## COLOCATION ANALYSIS LETTER

SUBJECT: Colocation Analysis Letter

SITE ID#: DN70XC032

SITE NAME: Falcon Middle School

Existing Coverage VS DO Upgrade

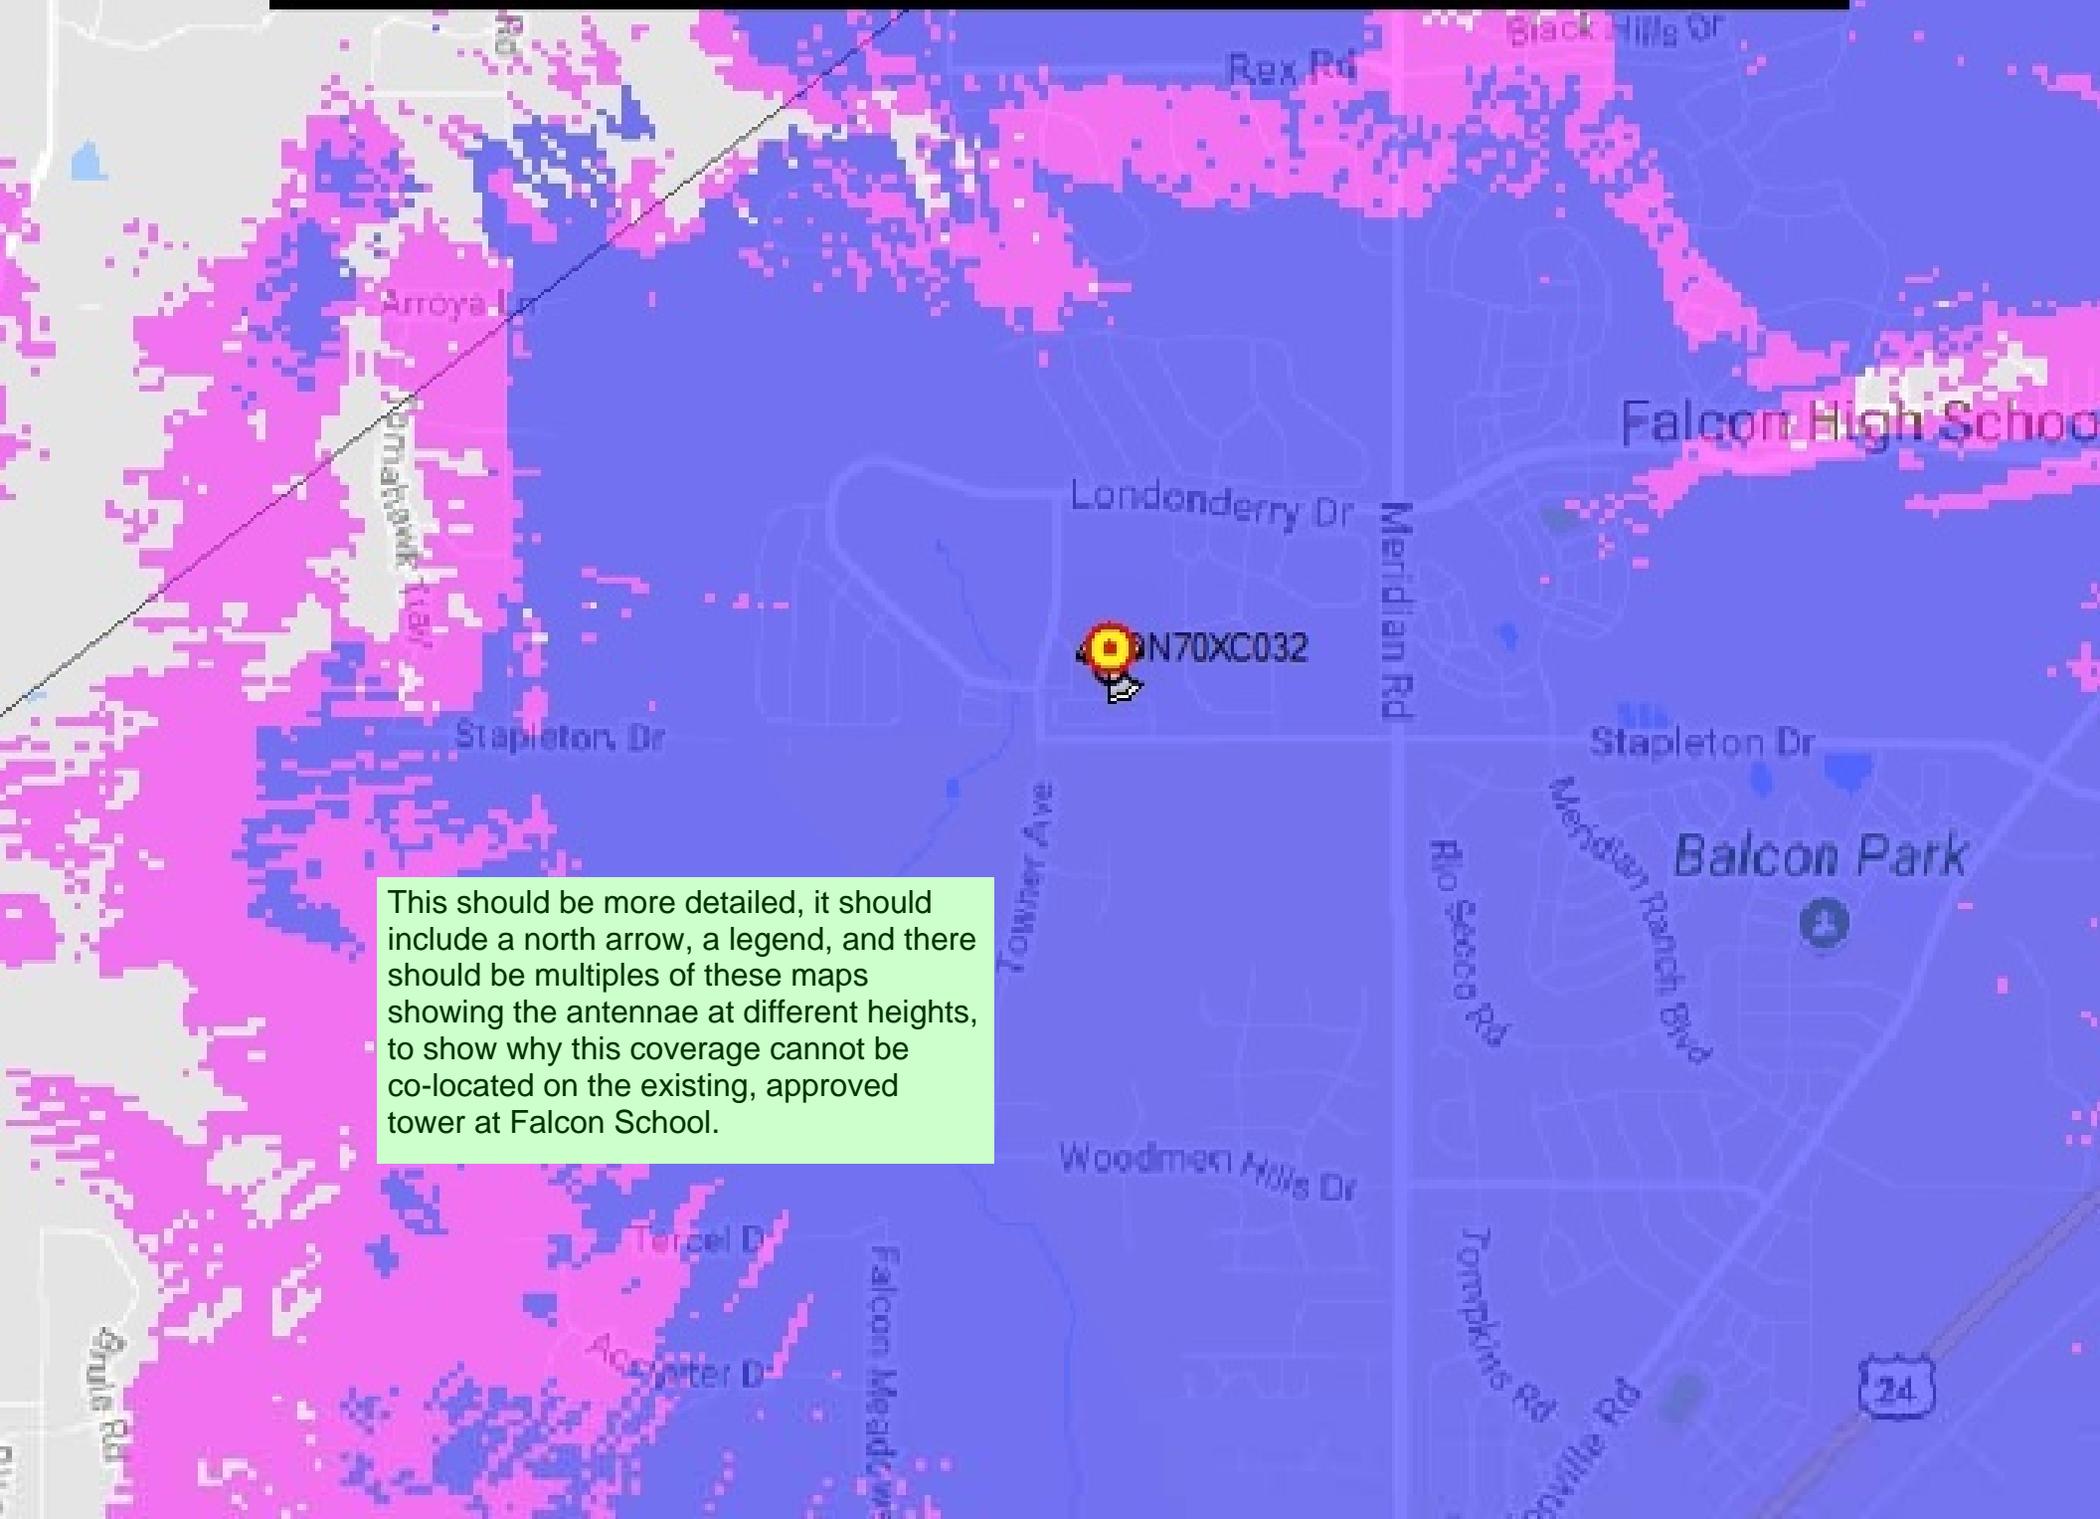
Show the difference in coverage for different heights in the coverage maps.

Show the difference in coverage for different heights in the coverage maps.
